Application Ref:	3/2025/0696			 Ribble Valley Borough Council www.ribblevalley.gov.uk
Date Inspected:	3/10/25 & 10/11/25	Site Notice:	3/10/25	
Officer:	BT			
DELEGATED ITEM FILE REPORT:				REFUSAL

Development Description:	Proposed demolition of existing bungalow, to be replaced with the erection of a new dormer bungalow on existing site.
Site Address/Location:	Markhor, Eaves Hall Lane, West Bradford, BB7 3JG.

Drawing Title
Proposed Floor Plans and Elevations

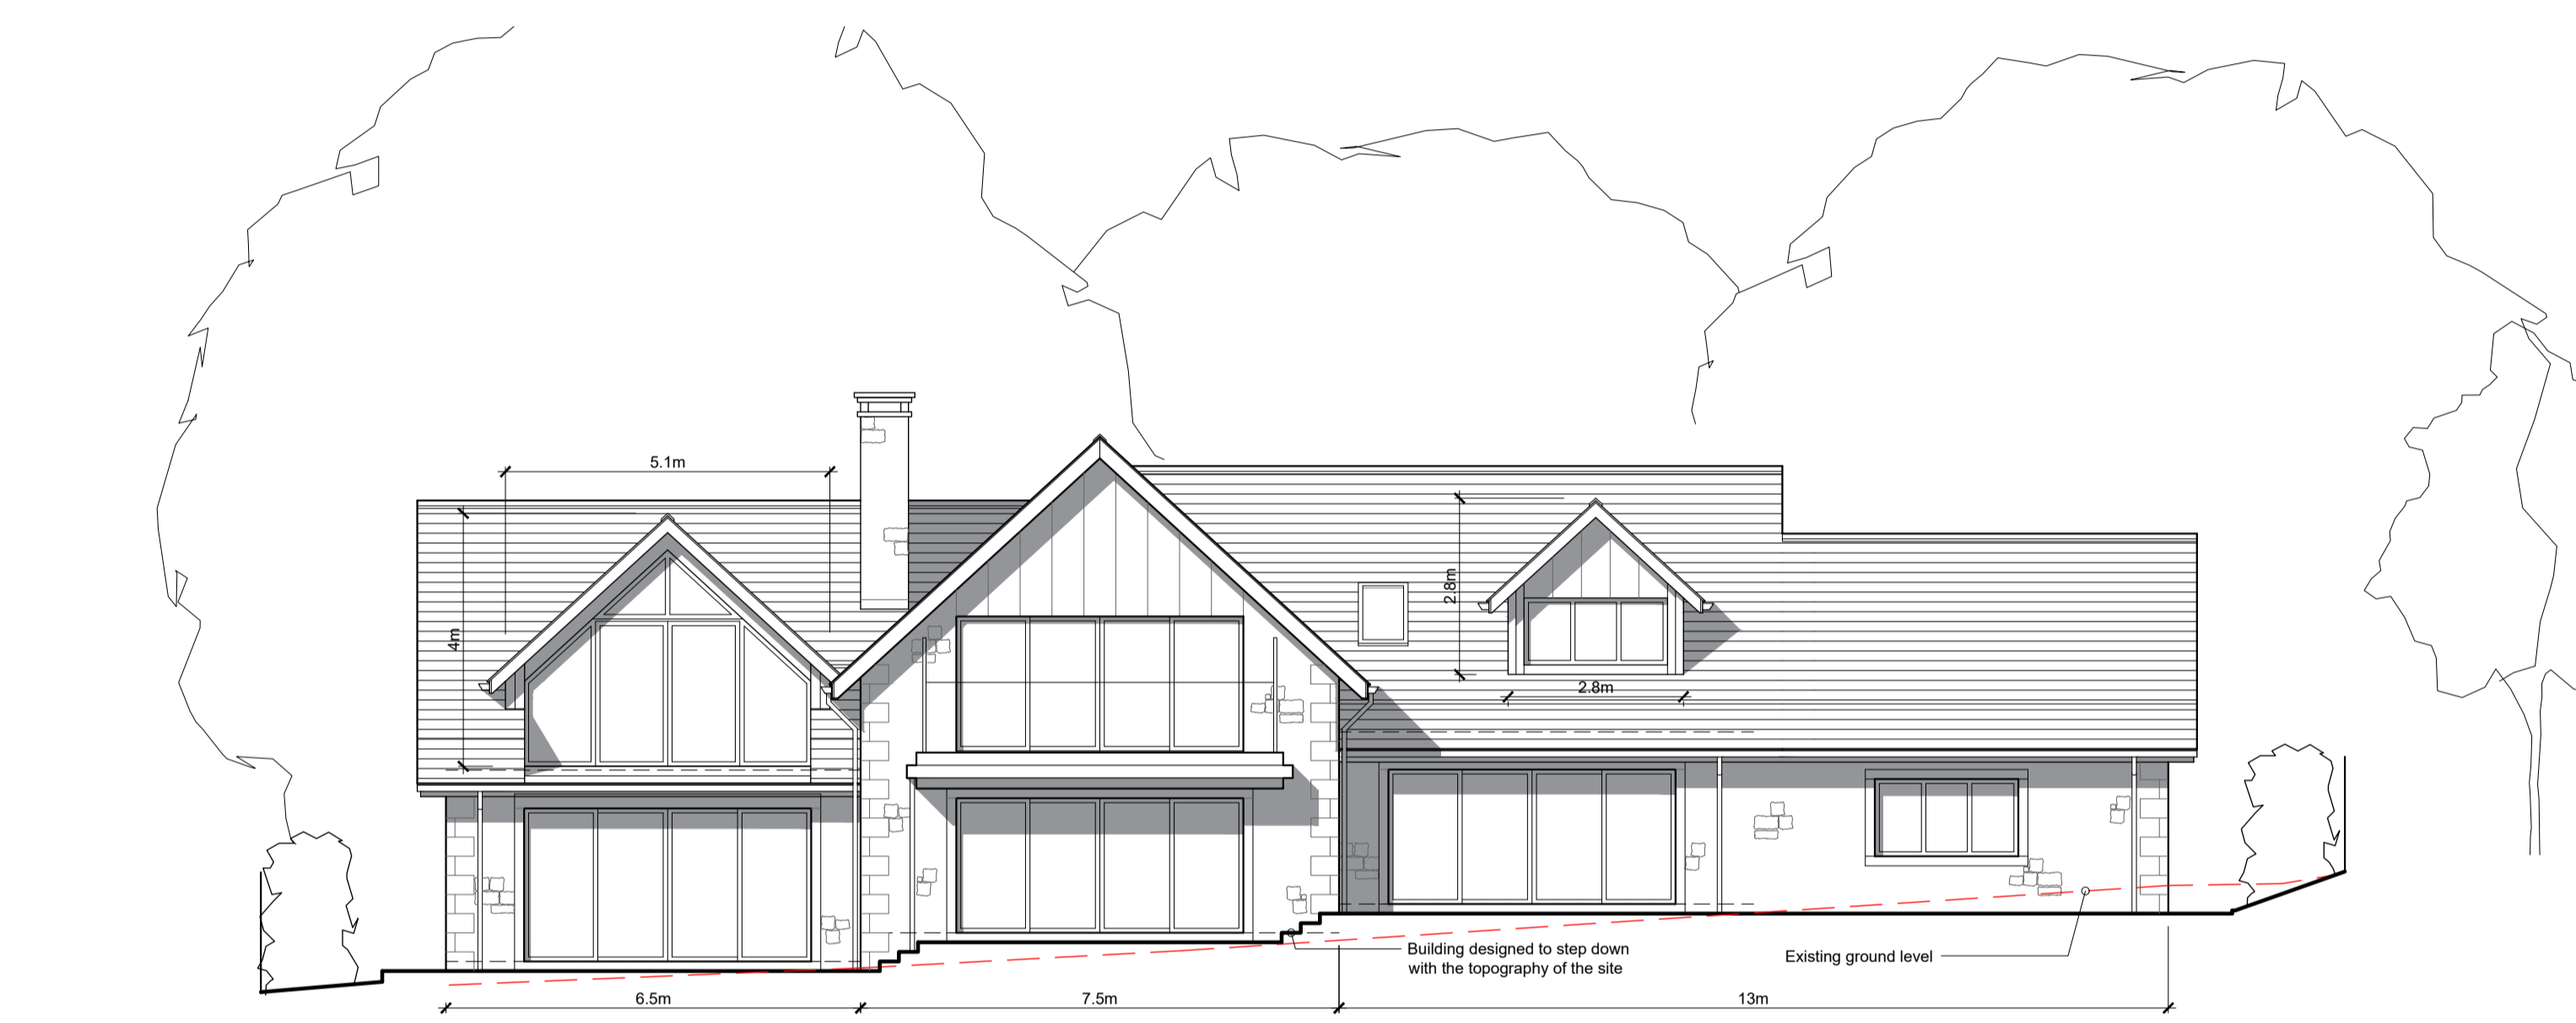
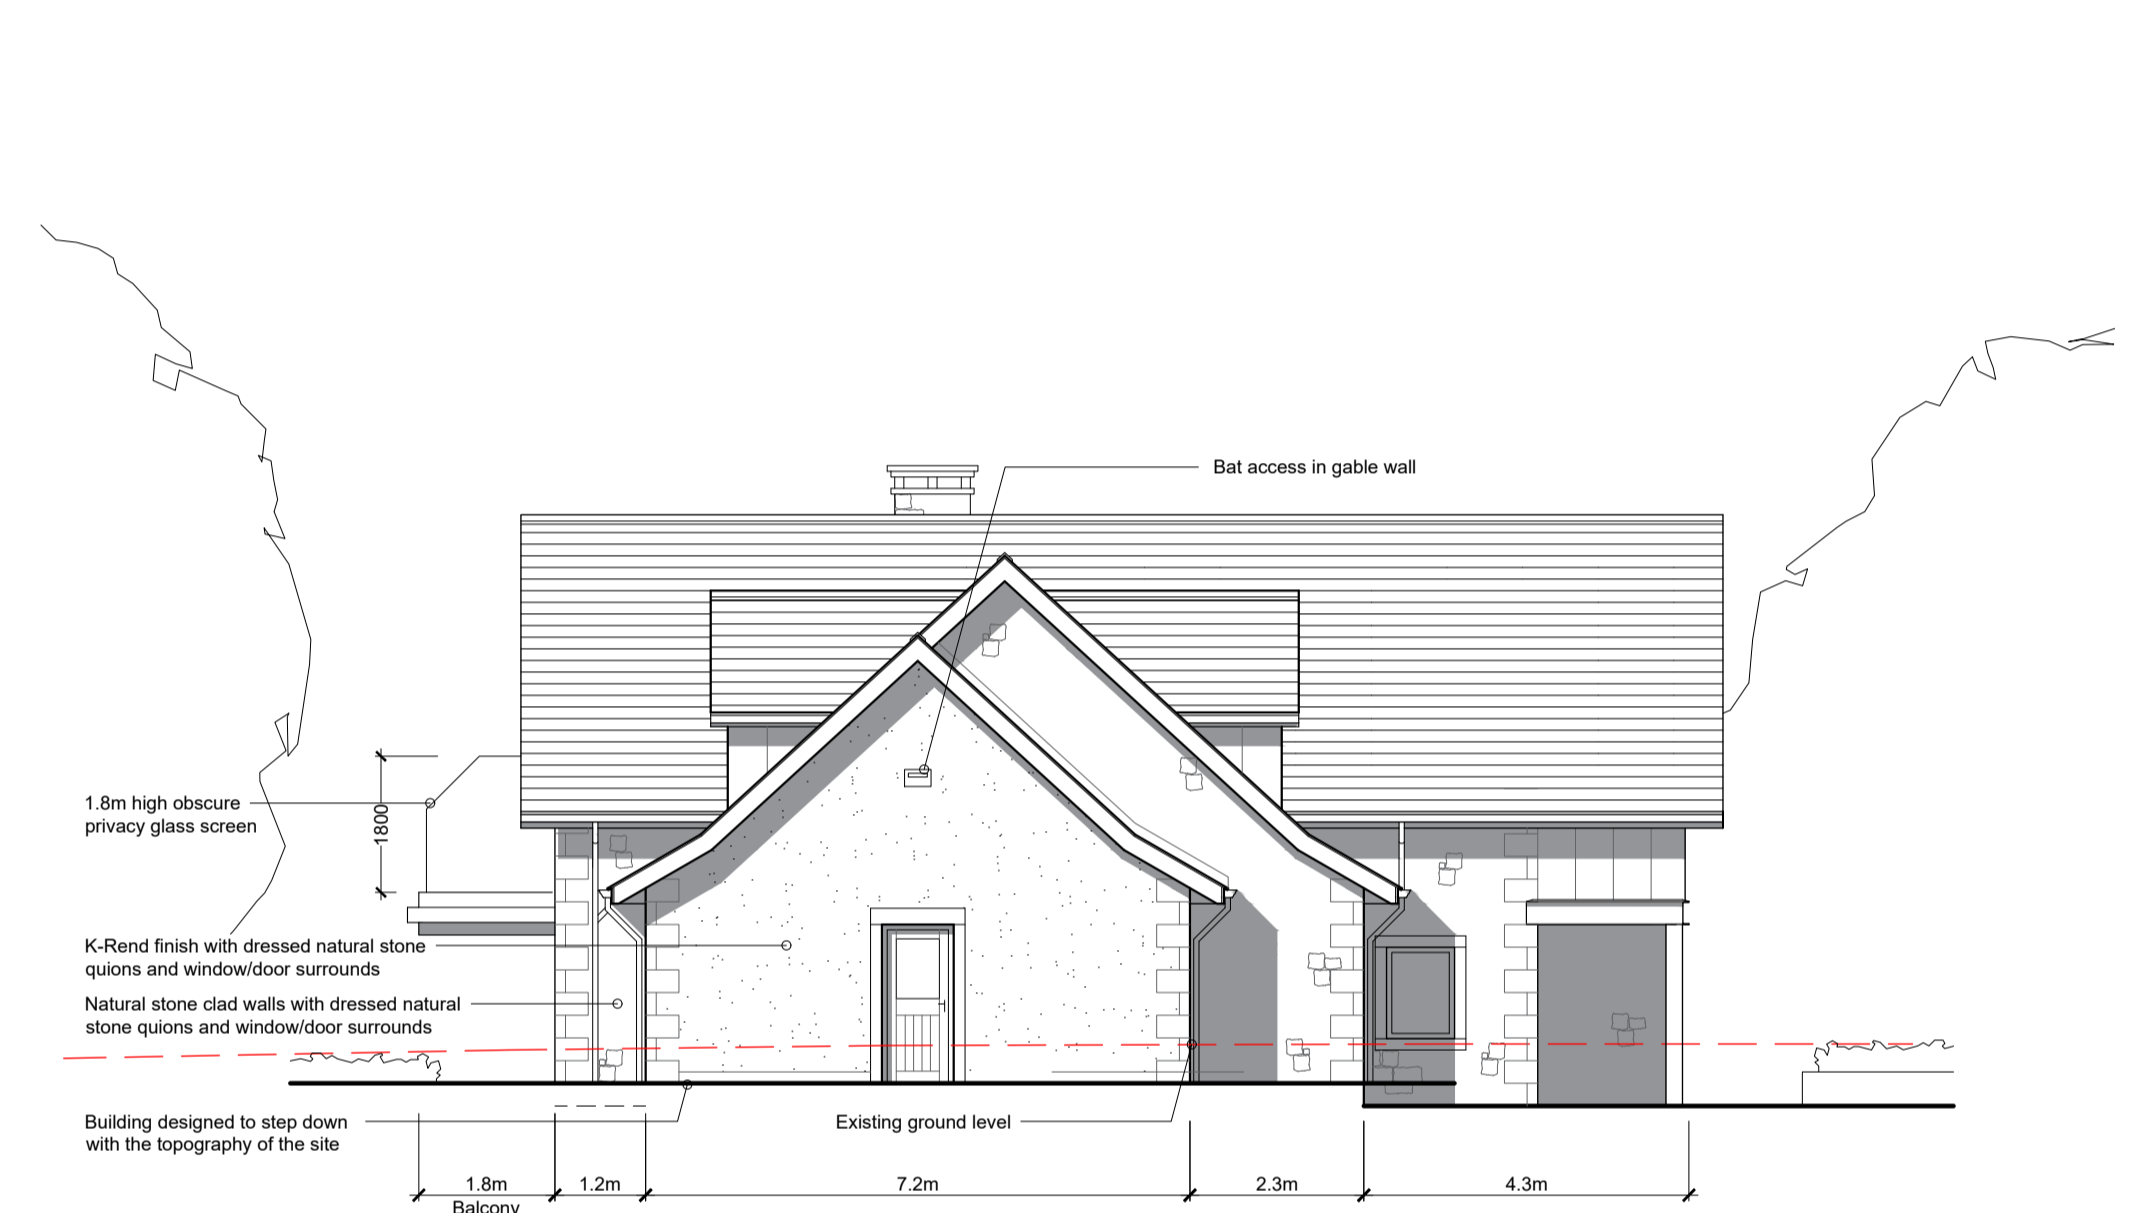
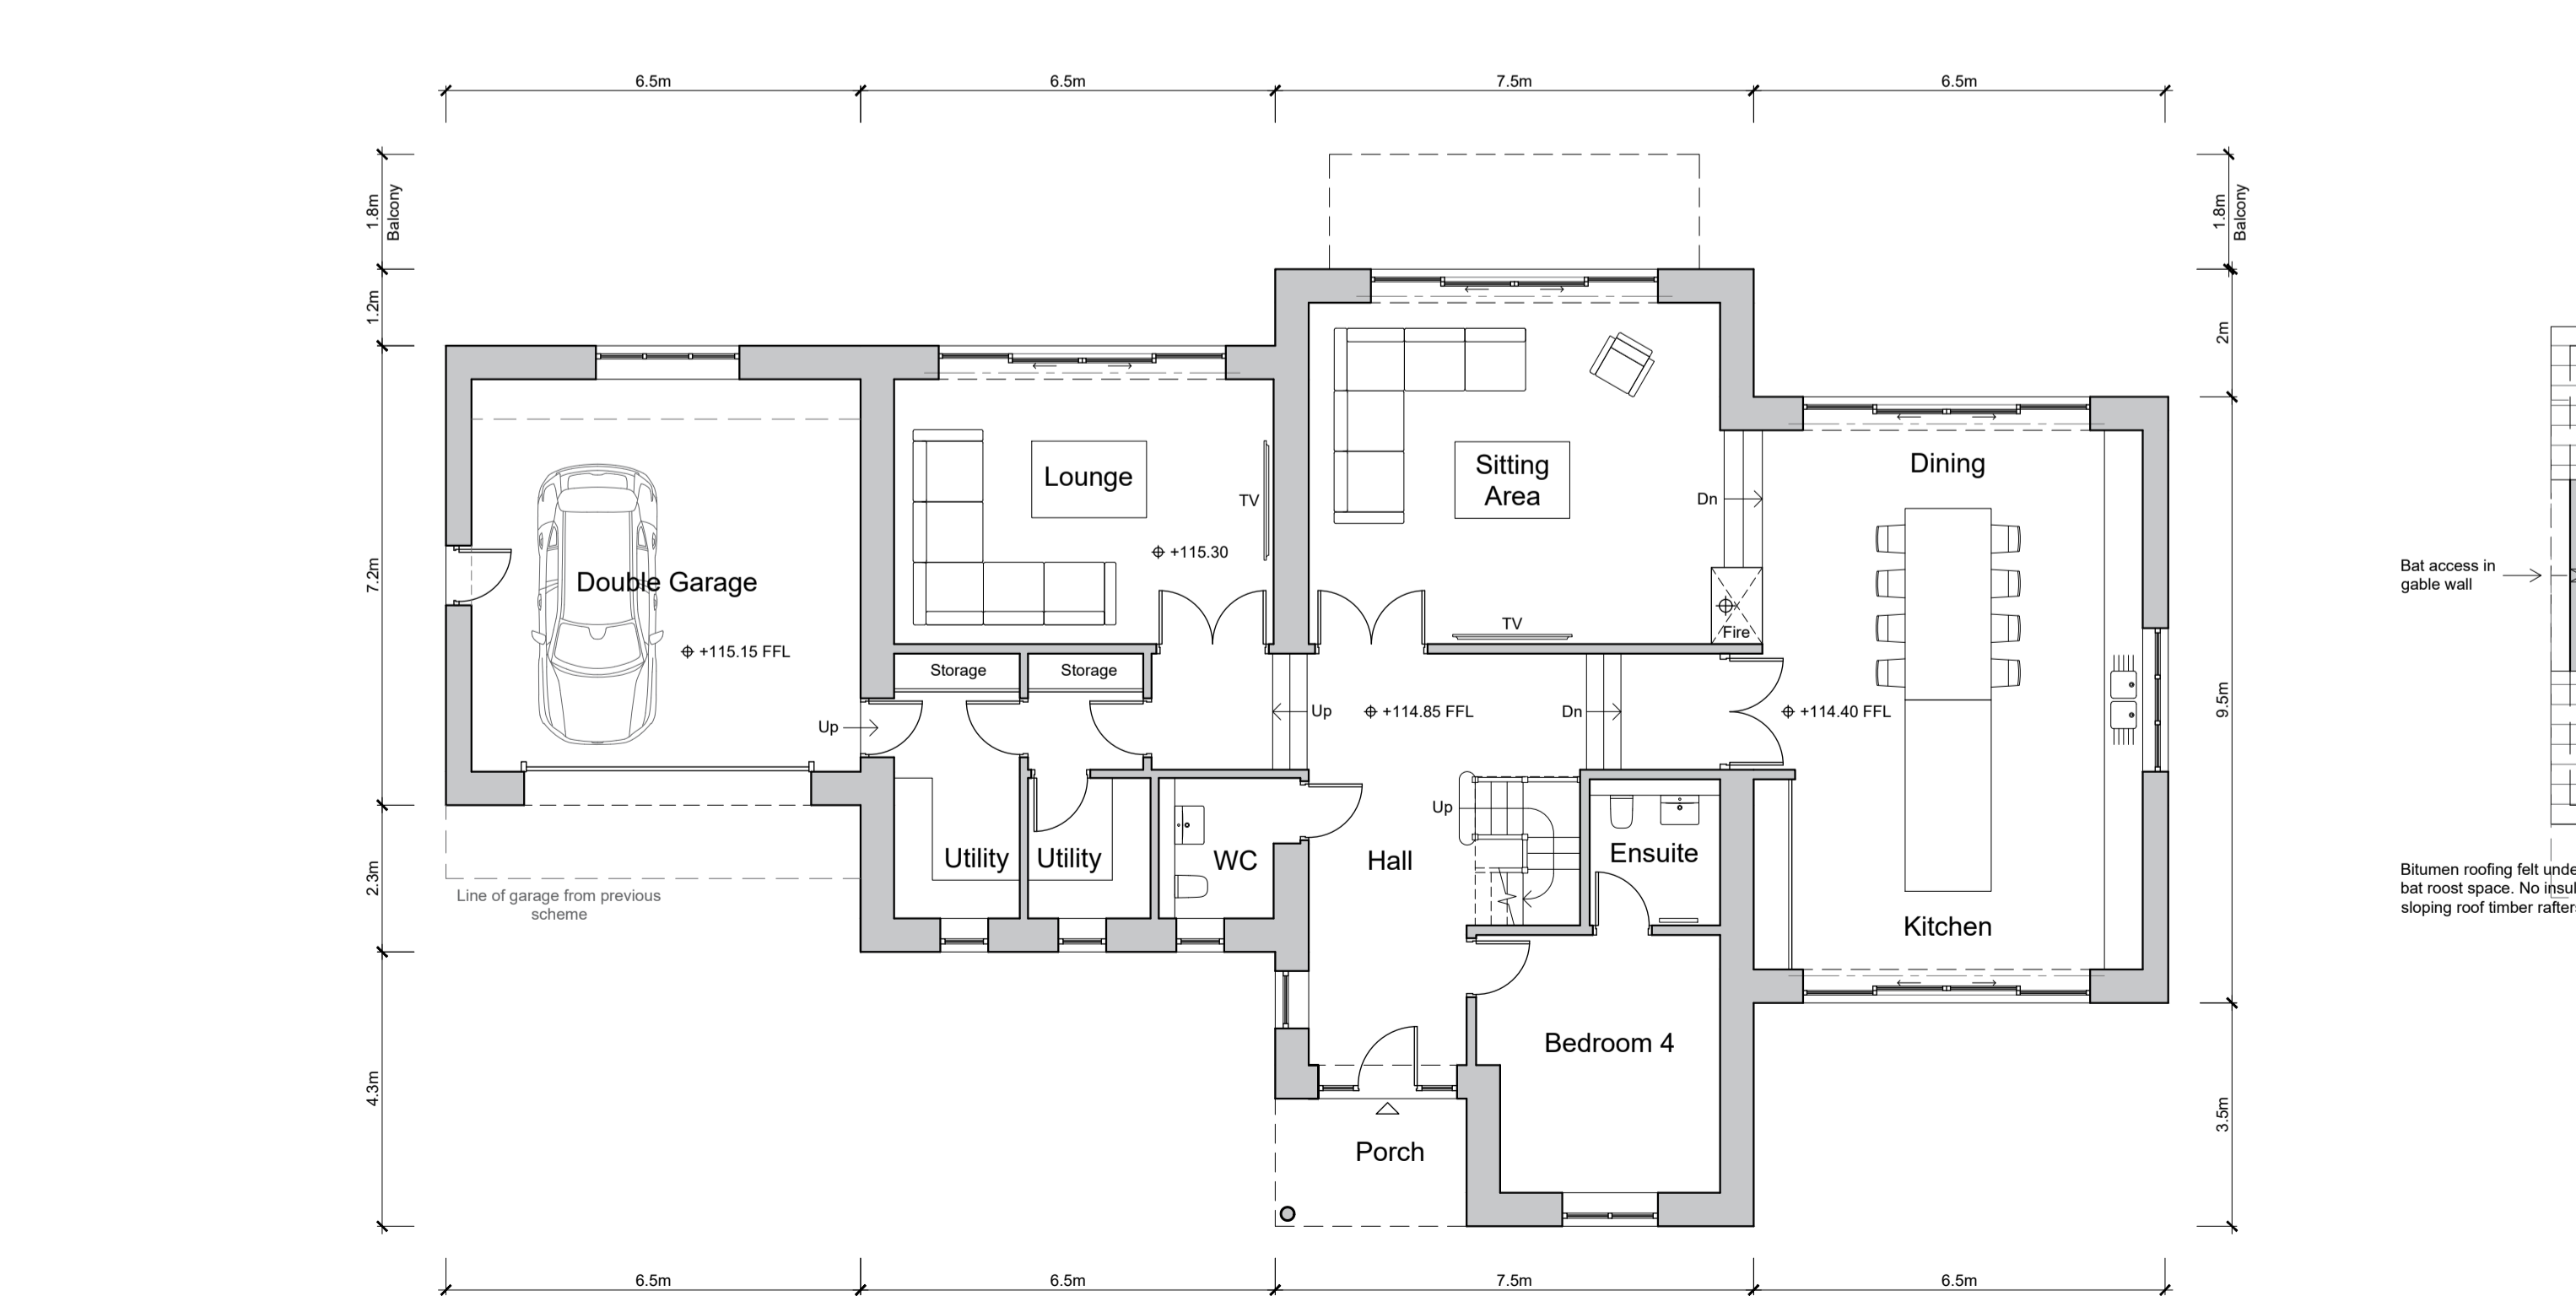
The proposed replacement dwelling would incorporate a projecting balcony on its rear North-eastern elevation however following concerns raised with the applicant with regards to the balcony potentially providing elevated unrestricted sideways views towards the adjacent neighbouring properties a 1.8m high privacy screen comprised of obscure glazing has been incorporated to the side elevations of the balcony which in turn would sufficiently safeguard the privacy of the adjacent neighbouring residents.

Notwithstanding this, the South-eastern elevation of the proposed dwelling would be sited in close proximity (approximately 3 metres away) to the common boundary shared with the adjacent neighbouring property of Highfield, with the rear North-eastern upper level of the proposed dwelling's South-western quadrant accommodating a fully glazed opening that would serve an exercise room. The fully glazed opening serving the exercise room originally accommodated two full height doors and a Juliet balcony and it was conveyed to the applicant that these features, in conjunction with the site's elevated topography above Highfield would likely allow for largely unrestricted sideways views into the rear neighbouring garden of Highfield which in turn could compromise the privacy of the neighbouring occupants (or at the very least create a distinct sense of being overlooked).

In light of the above issues, the applicant was advised to remove the proposed Juliet balcony feature from the dwelling and to relocate a dwelling of reduced width (either by way of removing the dwelling's double garage / storage component or kitchen & dining / exercise room component) to the centre of the

application site, so as to both address the aforementioned concerns with regards to overlooking and also additional concerns raised with respect to design and visual impact (as detailed below in the report's Visual Amenity/External Appearance' section). An amended proposal has since been submitted with the previously proposed Juliet balcony feature and full height doors having now been removed from the exercise room's rear facing fully glazed opening. Notwithstanding this, the originally proposed width and location of the replacement dwelling has been retained in the amended scheme, along with full height glazing to the North-eastern elevation of the exercise room. As such, given the height of the proposed glazed opening and its proximity to the neighbouring boundary, in conjunction with the elevated topography of the application site, the proposed development would allow for elevated and largely unrestricted views into and towards the rear garden area and lounge windows of Highfield respectively, as evidenced by the case officer's recent site visit photographs.

In contrast, the proposed dwelling would be orientated in the opposite manner with its elongated front and rear elevations facing South-west and North-east respectively. Whilst it is noted that the neighbouring property of Peveril is orientated in a similar manner, its orientation is not reflective of the prevailing alignment of dwellings within the existing street scene therefore the orientation of the proposed dwelling would be largely at odds with the existing pattern of development within the street scene on Eaves Hall Lane. Furthermore, the proposed dwelling would comprise a sizeable width of 27

metres which would be significantly wider than the neighbouring property of Peveril to the extent that the proposed dwelling would occupy the large majority of the application plot width. As such, the proposed dwelling would read as a disproportionate and cramped addition to the site relative to the width of the application plot and would therefore be noticeably at odds with the spatial pattern of housing forming the existing streetscene on the North-eastern side of Eaves Hall Lane. The proposal as originally submitted also proposed to incorporate metal cladding to the entirety of the upper face sections of the property's projecting gable features which was considered to be overtly modern in character and not wholly in keeping with the rural character of the area.

In light of the above issues, the applicant was advised to reduce the footprint of the proposed dwelling and re-site a dwelling of reduced width centrally within the application plot, along with a reduction to the extent of metal cladding within the faces of the dwelling's projecting gable features. An amended proposal has since been submitted with the extent of metal cladding reduced as advised however the 27 metre width of the proposed dwelling has been retained, with the only change to the dwelling's footprint being a further (minor change) step back incorporated to the footprint of the dwelling's integral garage component. Furthermore, whilst the height of the replacement dwelling would be similar to height of existing property, the dwelling's sizeable width in conjunction with its overhanging gable roof profiles and projecting front and rear two-storey gable features would collectively exacerbate the overall bulk and massing effect of the proposed development to the extent that the replacement dwelling would read as a disproportionate, over dominant and incongruous addition to the application site and existing street scene.

Taking account of all of the above, it is considered that the proposed replacement dwelling by virtue of its orientation, width, bulk, massing and height would amount to an over dominant, unsympathetic and incongruous form of development that would be at odds with the prevailing character of residential development within the existing street scene on Eaves Hall Lane. Accordingly, it is considered that the proposed development would be harmful to the visual amenities of the area and for this reason it is not considered that the proposal would in this instance conserve or enhance the character of the surrounding National Landscape. The proposal would therefore fail to satisfy the requirements of Paragraphs 135 (C) and 189 of the NPPF and Key Statement EN2 and Policies DMG1 and DMG2 of the Core Strategy.
